**Re: McDonald's at 2000 Gibson Blvd SE  
Erosion and Sediment Control Plan  
Engineer's Stamp Date – 01/10/25 - M15E021G (SWQ-2025-00024)**

Based upon the information provided in your submittal received 5/6/25, the above-referenced ESC Plan cannot be approved until the following comments have been addressed

# EROSION CONTROL PLAN

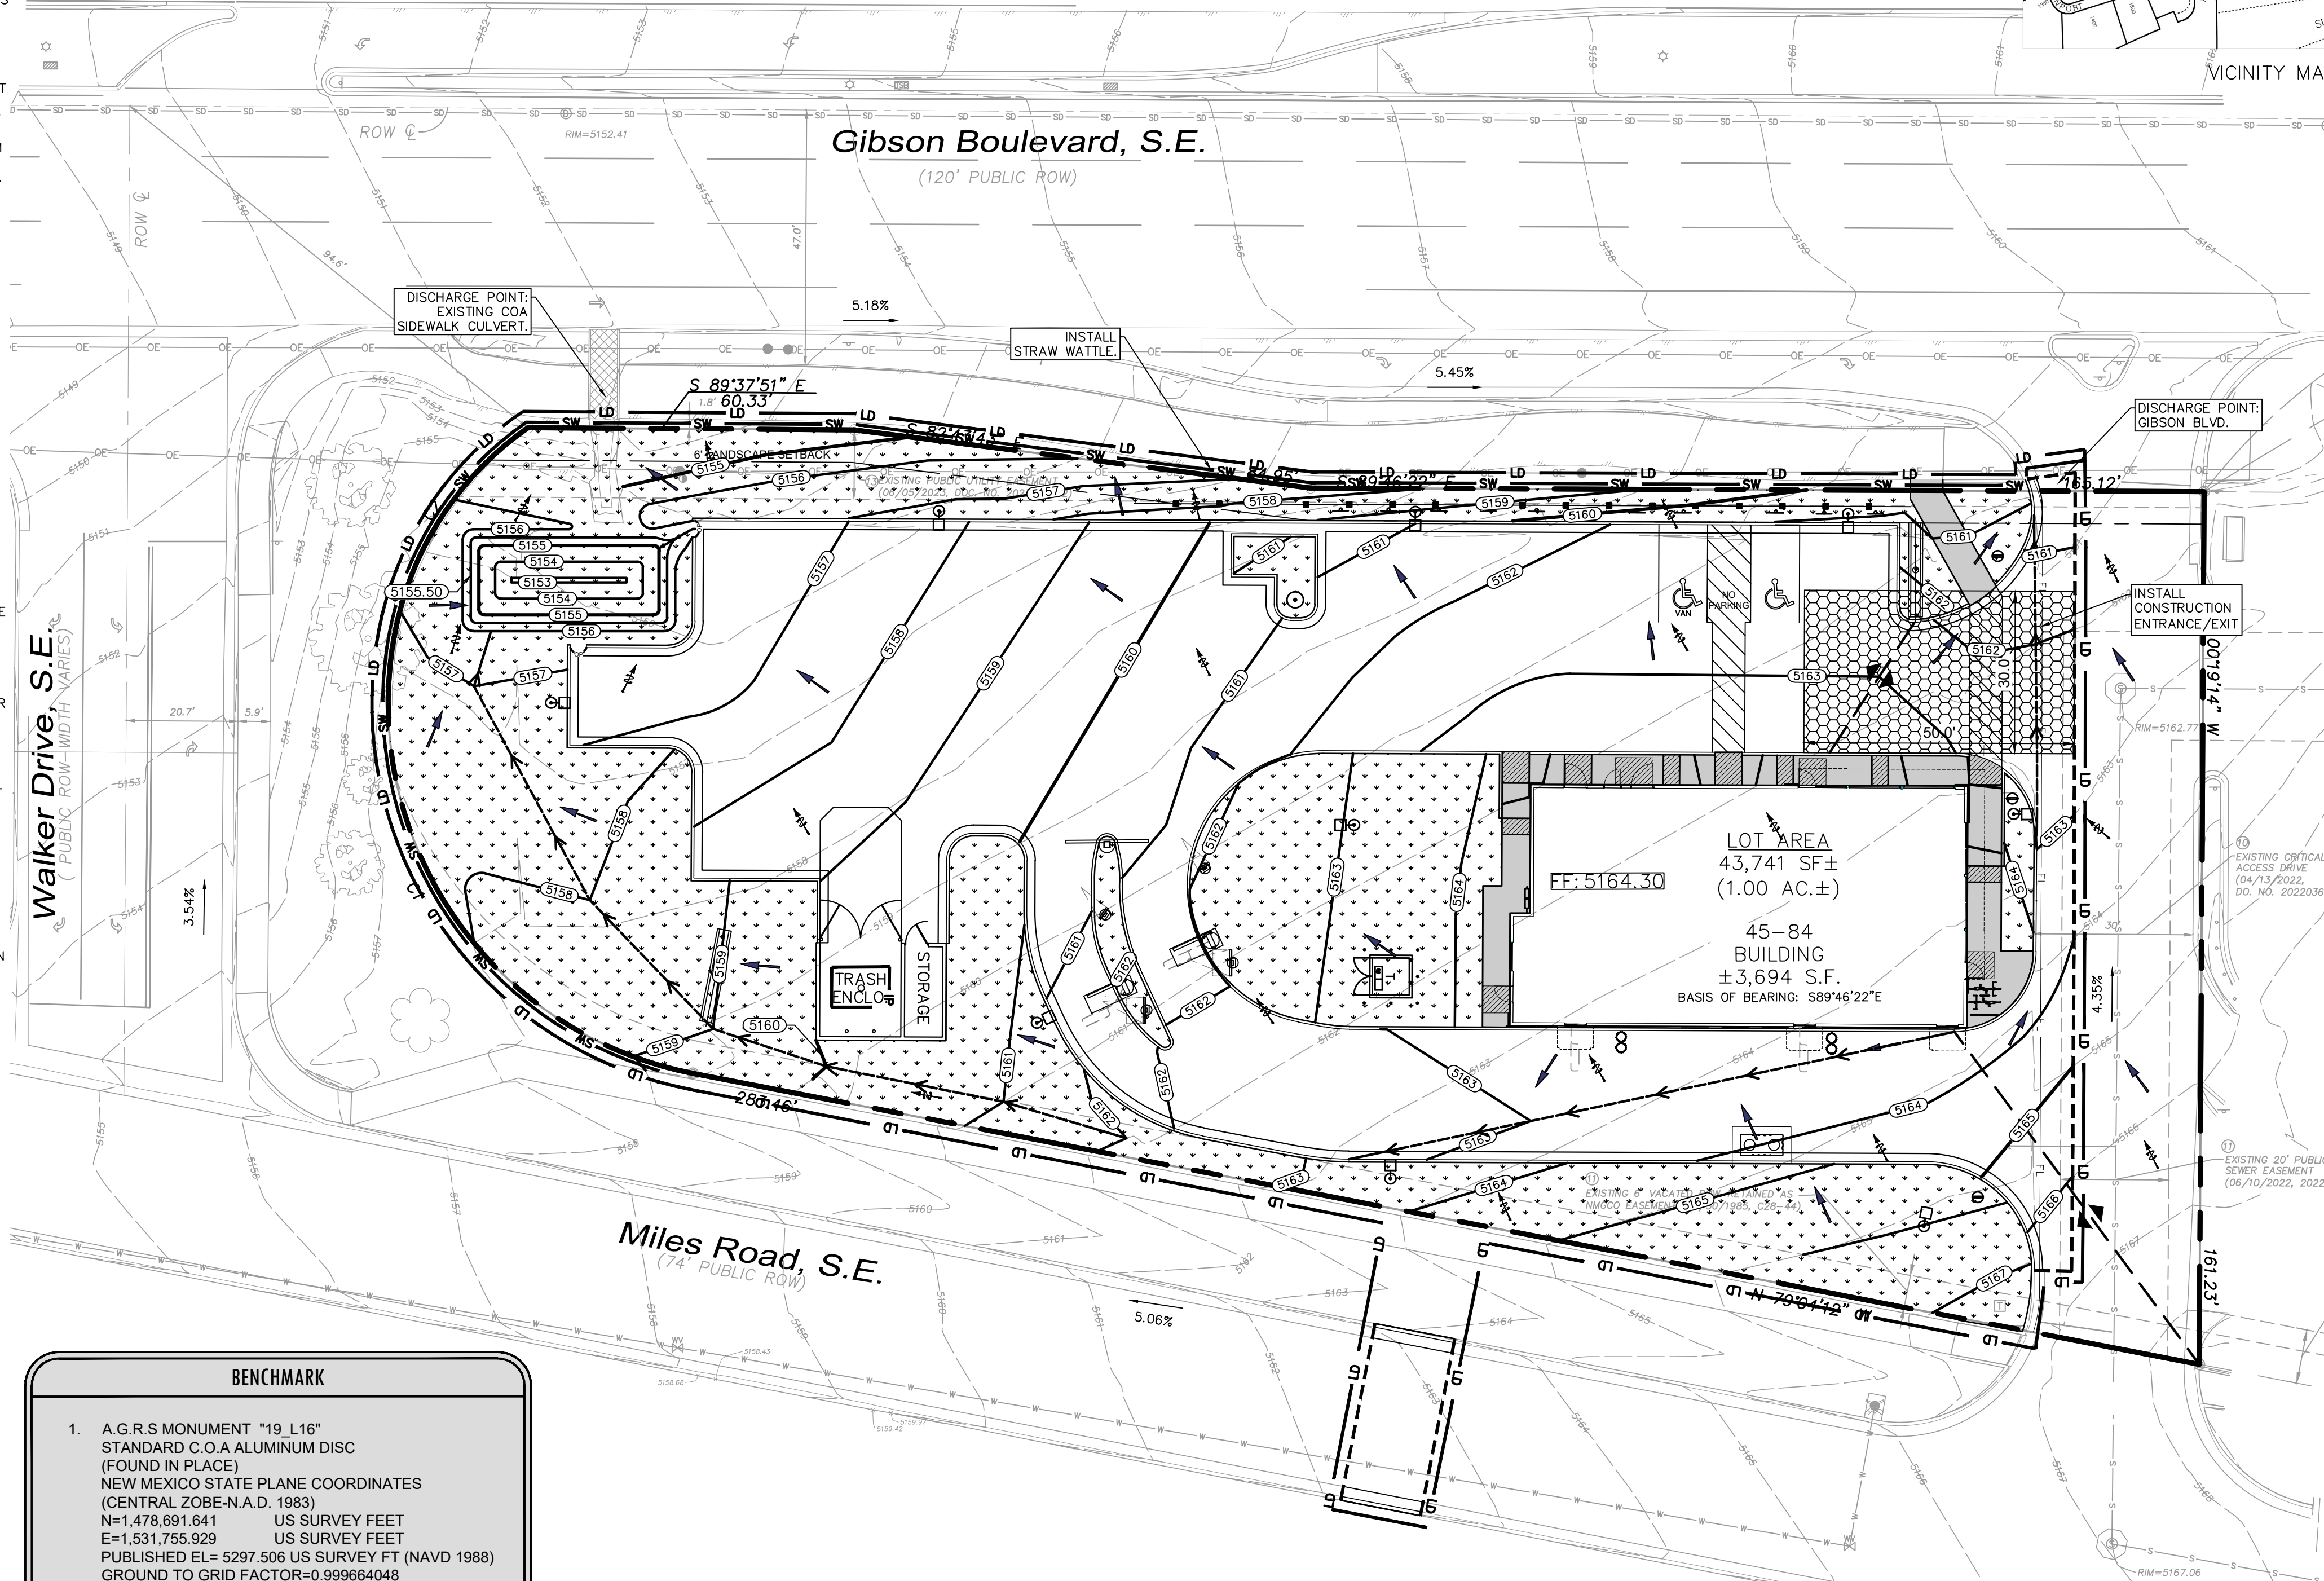
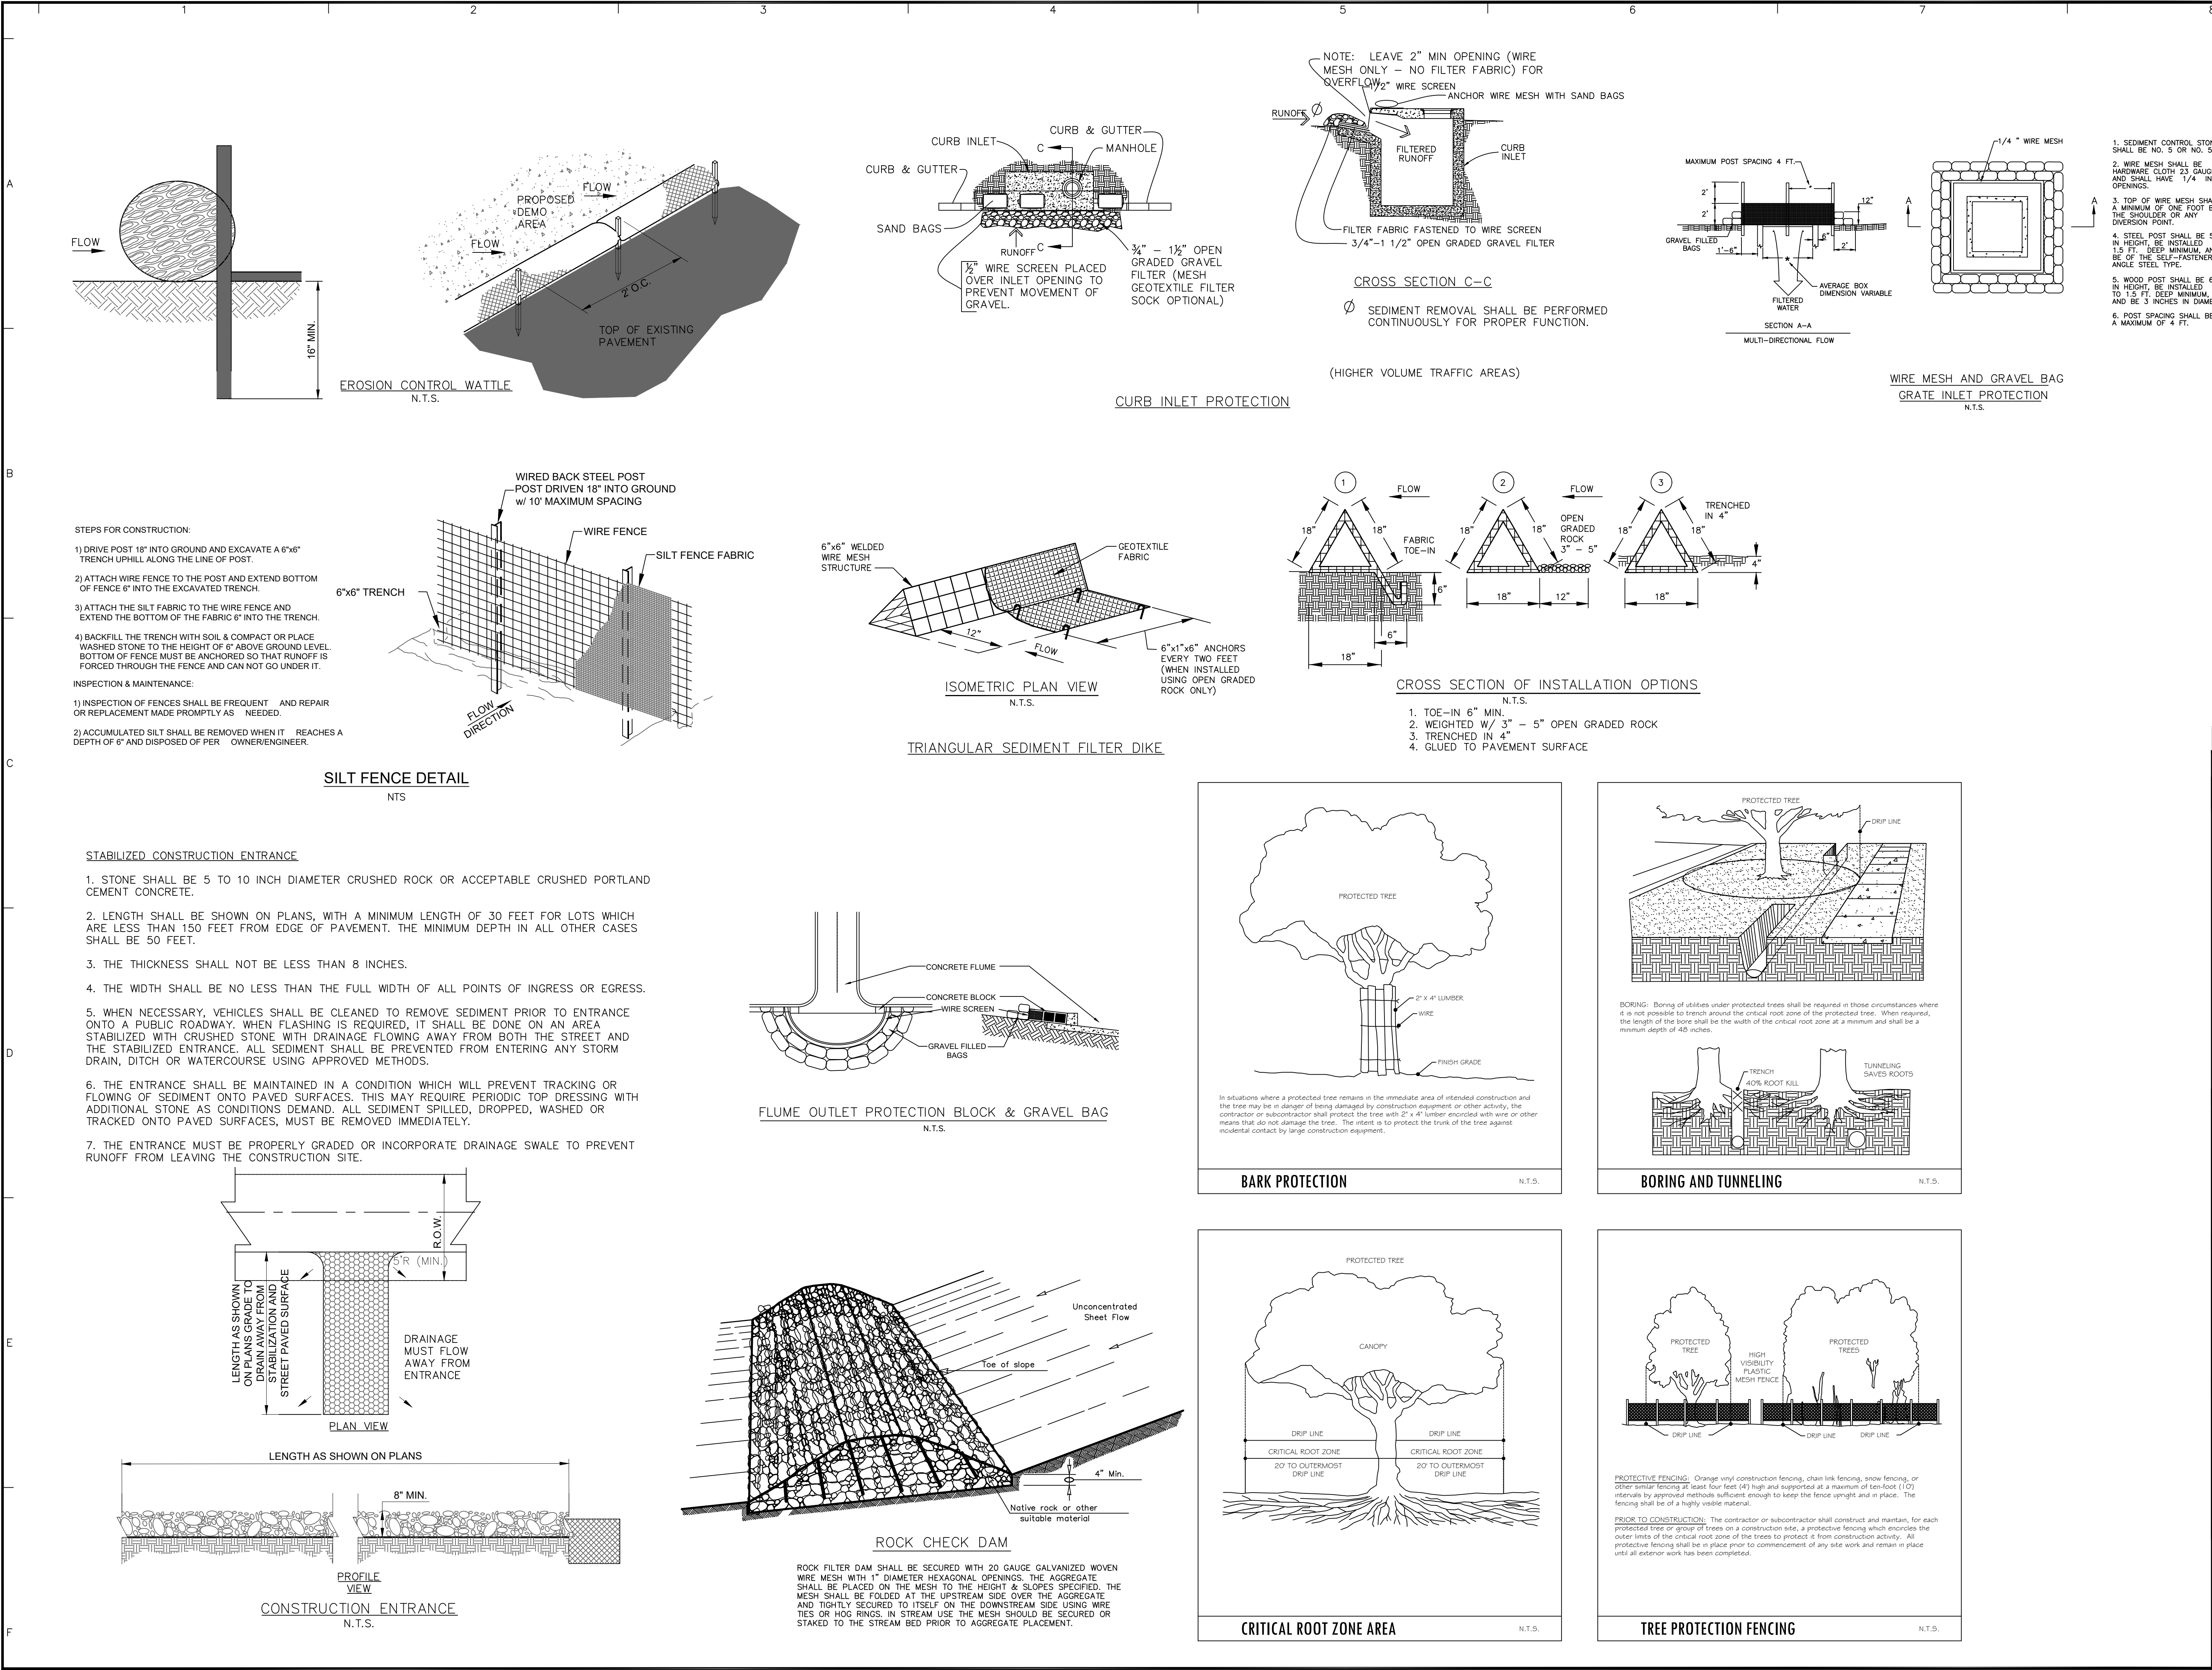
1. This 1-acre property, Lot A of the Lovelace Heights Addition Plat and Site Plan, is part of a 7.5-acre "Common Plan of Development or Sale" (CPODS). One part or another of the Lovelace Heights Addition CPODS has been under construction for five years. Since there has never been a period when the entire CPODS has been stabilized, the area of the CPODS can't be reduced and remains at 7.5 acres. According to CGP 9.6.1.c.i, "for sites greater than 5 acres in size, the BMP selection must be based on the use of appropriate soil loss prediction models". Since this site was all paved before development, the predevelopment sediment yield was zero, and the only way to maintain zero sediment yield during construction, as required by CGP 9.6.1.c.ii, is to not discharge any stormwater from the disturbed site during construction.

- a. Add a description of undisturbed and pre-construction ground cover (CGP 7.2.4.e) to the ESC Plan.
  - b. Soil information – add a table with name type, particle sizes, and Erodibility factor (CGP 2.1.1).

- c. Identify the existing and proposed drainage patterns of this site and its "Discharge Point" per CGP 7.2.4.f.
2. Add a temporary diversion berm to the ESC Plan along the north edge of the proposed parking lot to divert onsite flows into a temporary sediment trap sized to retain 3,600 cubic feet per acre or all of the excess precipitation from the 2-year storm, as per CGP 2.2.12. Add the berm construction to the sequence of construction as one of the first items, simultaneously with the demolition of the existing pavement. Add the removal of the berm to the sequence after the C&G is constructed along the north side of the parking lot.

3. A temporary sediment trap must be constructed upstream of the concentrated discharge point as one of the first items of construction, at the same time as the existing pavement demolition. The temporary sediment trap will be located in the same area as the permanent stormwater quality pond. However, the required size of the temporary sediment basin is based on significantly more precipitation than the permanent pond, so it will require a larger area, potentially overlapping with a portion of the parking lot. Include design calculations, construction details, and specifications for the temporary sediment trap in accordance with CGP 2.2.12 and standard engineering practice per CGP 2.1.2 and CGP 9.6.1 in the ESC Plan resubmittal. Add the sediment trap construction as the first item in the sequence of construction, and its removal as the last item after the rest of the site is constructed and stabilized.

4. Specify both temporary and permanent stabilization at the discharge point to prevent erosion per CGP 2.2.1.b and 2.2.1.1.

5. The wattle on the north edge of the site isn't "on contour," so it isn't in keeping with standard engineering practice. Even though most of the drainage area will be diverted to the temporary sediment trap by the temporary berm, the wattle isn't a sufficient control if it isn't installed according to standard practice. Please consider establishing the final grade in the area below the berm and providing immediate final stabilization after grading, rather than using wattle. Final stabilization isn't specified on the ESC Plan for either the SWQ Pond or for the slope, but "Slope & Pond Stabilization per City Standard Specification 1013" is appropriate, and the timing of the slope stabilization should be identified early in the sequence of construction.

6. The SWPPP must include site-specific interim and permanent stabilization per CGP 9.6.1.c.i. The Landscape Plan and Work Order sheets can be used to satisfy this requirement and should be submitted separate from the ESC Plan with the application to the Stormwater Quality Section of the Planning Department, and they should be included in the SWPPP. Provide a specification on the ESC Plan for any disturbed areas not covered by the Landscape Plan.
